**Consultation Response from KC,
Highways Development Management**

**2026/90975 Land adj, Victoria Spring Business Park, Wormald Street, Millbridge, Liversedge,
WF15 6RA**

Erection of an industrial/commercial unit (Use Class B2)

Ref to Plans: 90102-01150-P01 - Proposed Site Plan and Ground Floor Plan - Unit 1; 25048-106 (B) _ Visibility Splay Layout Plan - Phase 1; 25048-109 (A) _ HGV Swept Path Analysis - Phase 1

**PROJECT**  
Land Adj. Victoria Spring Business Park  
Wormald St.  
Liversedge  
WF15 8EU  
DRAWING TITLE  
Proposed Site Plan - Unit 1

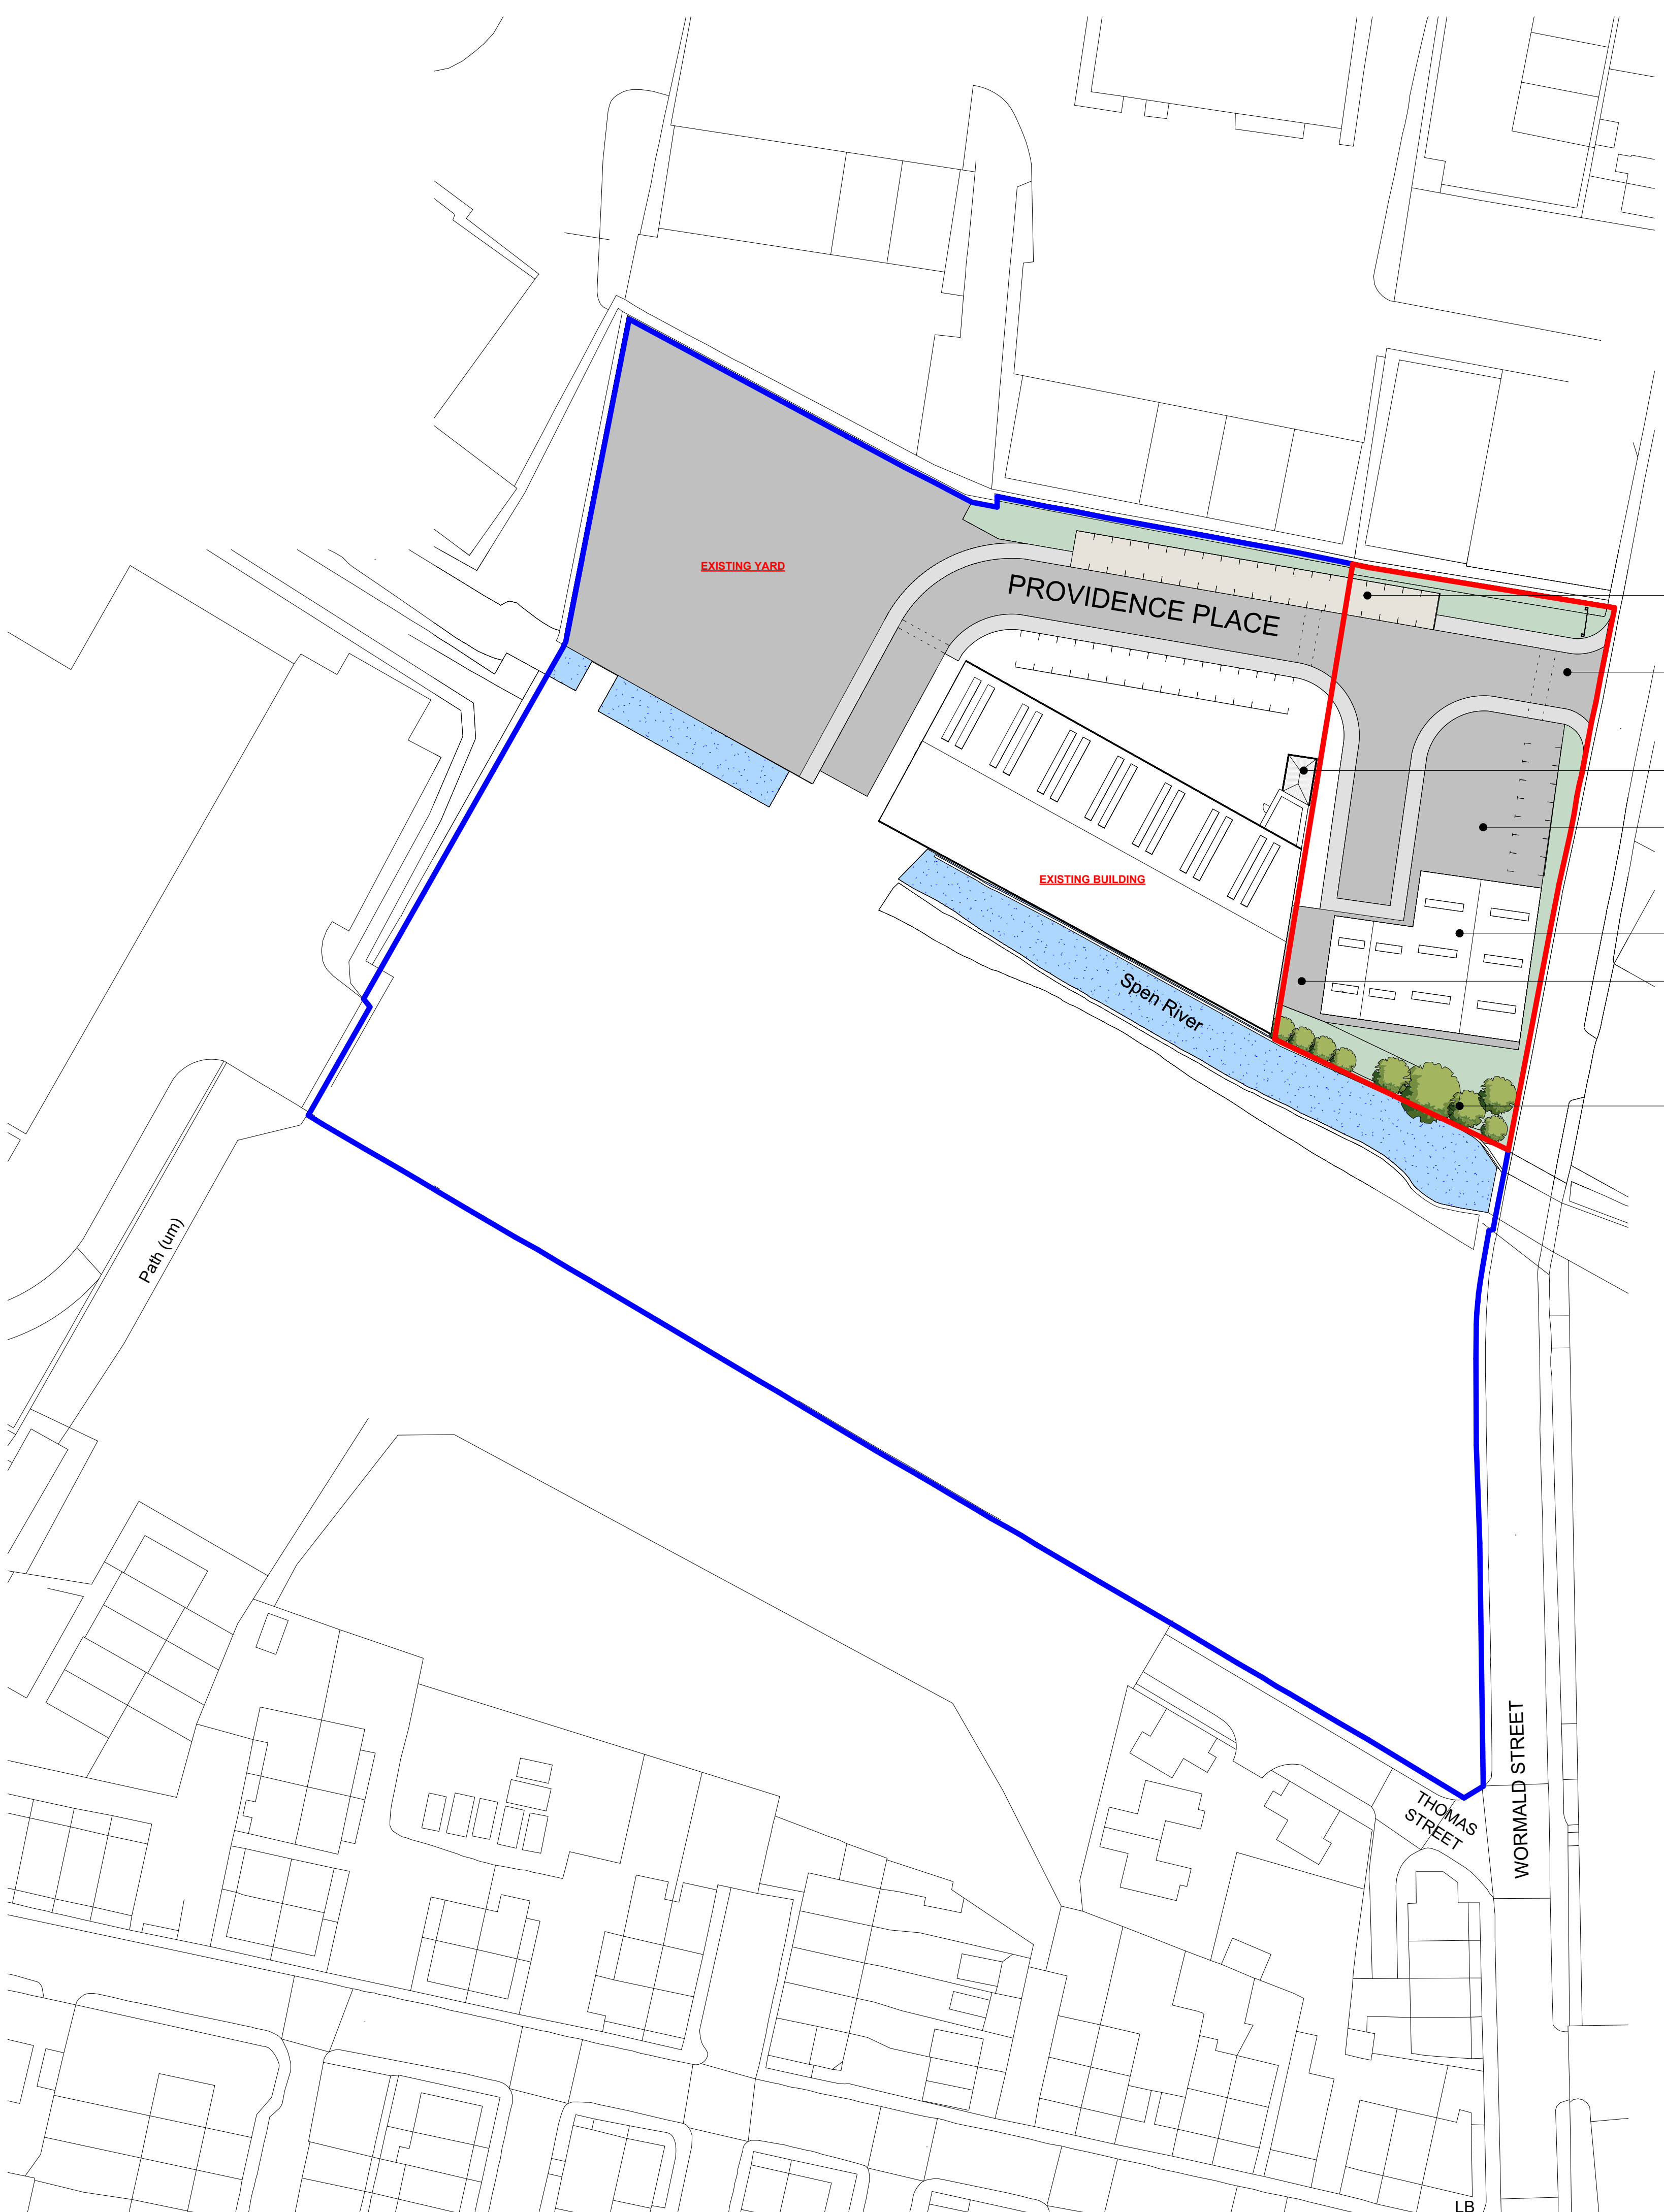
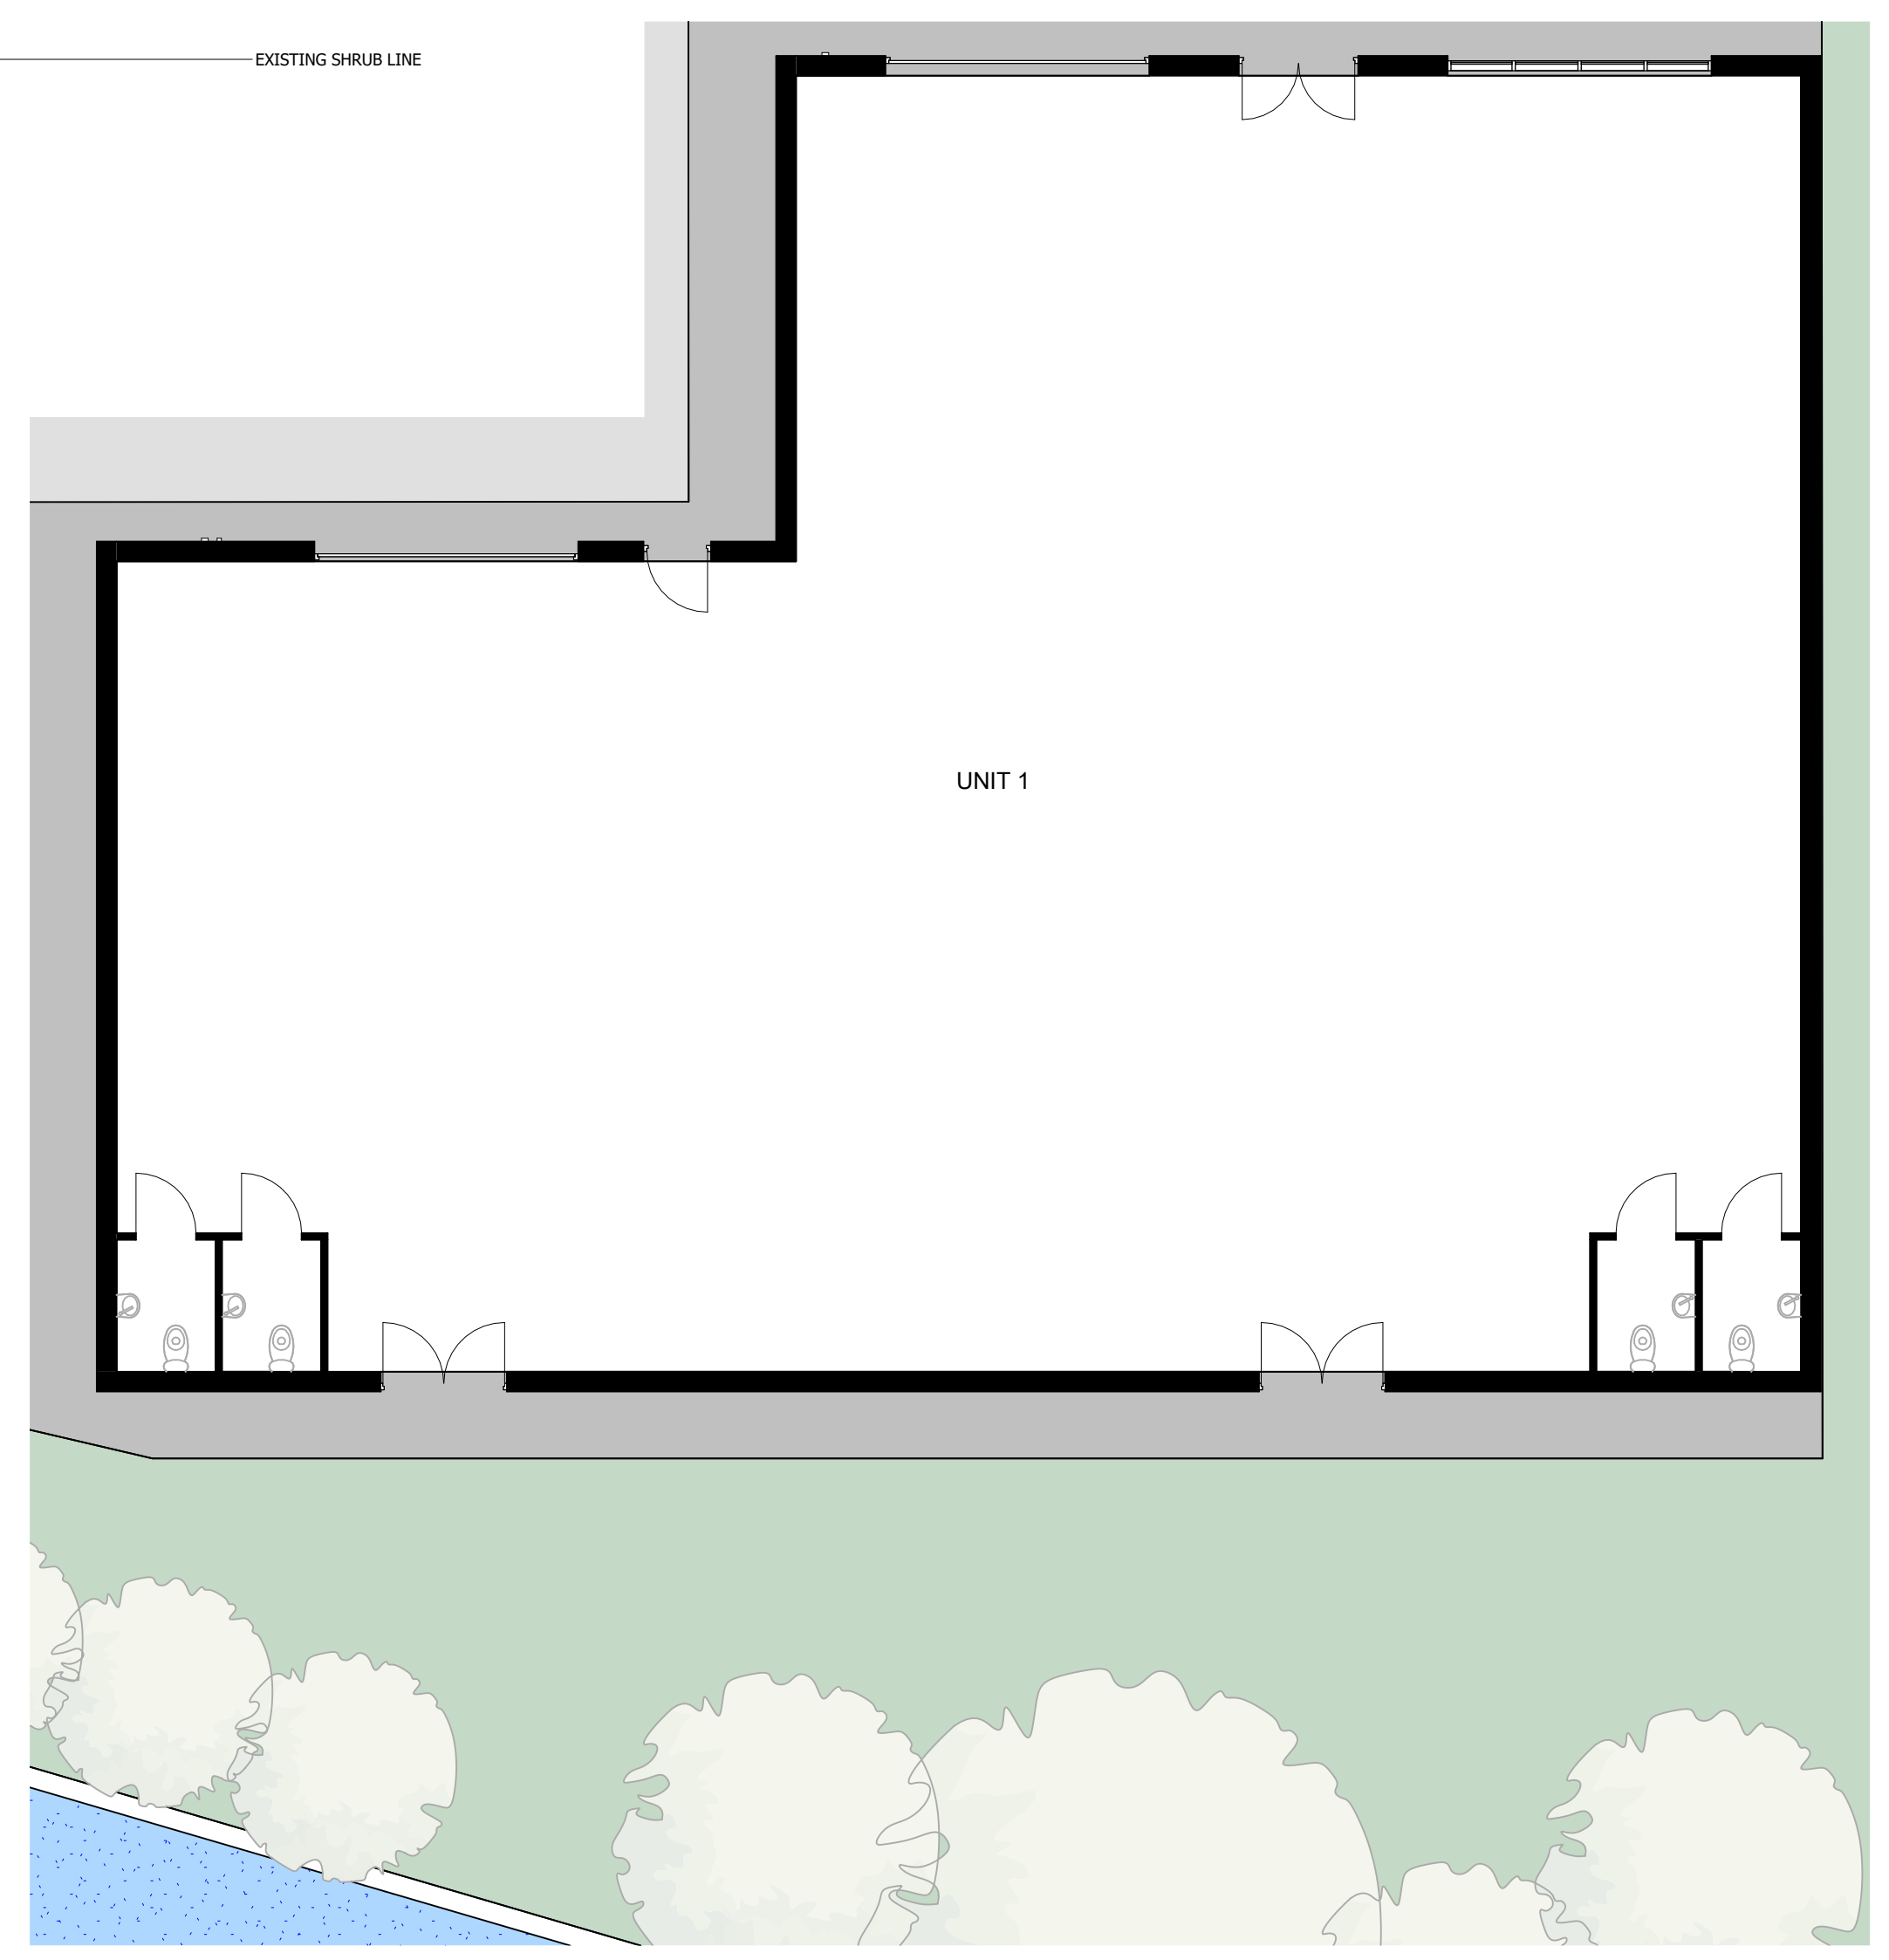
Details for approval are necessary of the position of both cycle parking and evcp's and the form of the cycle parking.

Internally, within the red line of the proposal site, the existing access way is to be widened, and a further street provided to the south before it continues westwards into the blue line. The southern link provides a turning point and leads to a loading dock. There is a yard with six or seven car parking spaces and bin storage depending on the plan referenced. A further five car parking spaces are shown within the red line towards the northern boundary of the site.

Again, there are inconsistencies between the plans. It is unclear how the loading dock within the yard and car parking are reached since there is no crossing point shown of the kerb line / margin. The hgv parking to loading dock within the yard appears to obstruct the main door to the building. There are no designated paths illustrated.

The amount of car parking is likely to be sufficient for a light industrial unit but is limited to that within the red line of c12 spaces and not the quantum of 42 an increase of 27 as indicated on the Application Form which appear to relate to the existing building on site and others for future phases with many of these falling within the blue line. There is need for demarking an allocation at the north too.

TITLE
**SWEPT PATH ANALYSIS
 HGV**

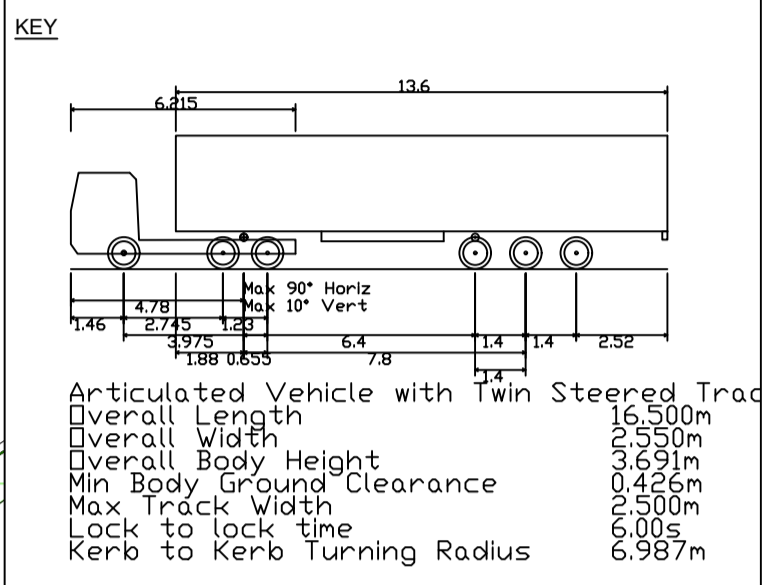
The industrial estate street widths and radii sizes are inconsistent between the drawings for the visibility splays 25048-106 (B) and 25048-109 (A) swept path analysis. Drawing 25048-106 (B) is more consistent with minor industrial streets criteria within the Kirklees Street Design Guide SPD. Additionally, the swept paths are too tight clipping the footway of each of the access junction radii and that opposite side of Wormald Street.

Clarification is necessary of the access layout together with revisions of the drawings and the swept path to demonstrate clearance and satisfactory turning.

The swept path analysis does not show manoeuvres to and from the yard loading dock. Instead, it shows the turn to and from the southern link and dock as well as extending into the blue line at west where future phases are depicted. It suggests too that two articulated vehicles are unable to pass along the estate road and clarity is necessary of the occurrence should the site be extended into the blue line as depicted. There is need to confirm too that the area within the blue line is available for use for the manoeuvres serving the proposed unit and does not become gated. There is space for waste bin storage, but no details are illustrated of the form of the storage.
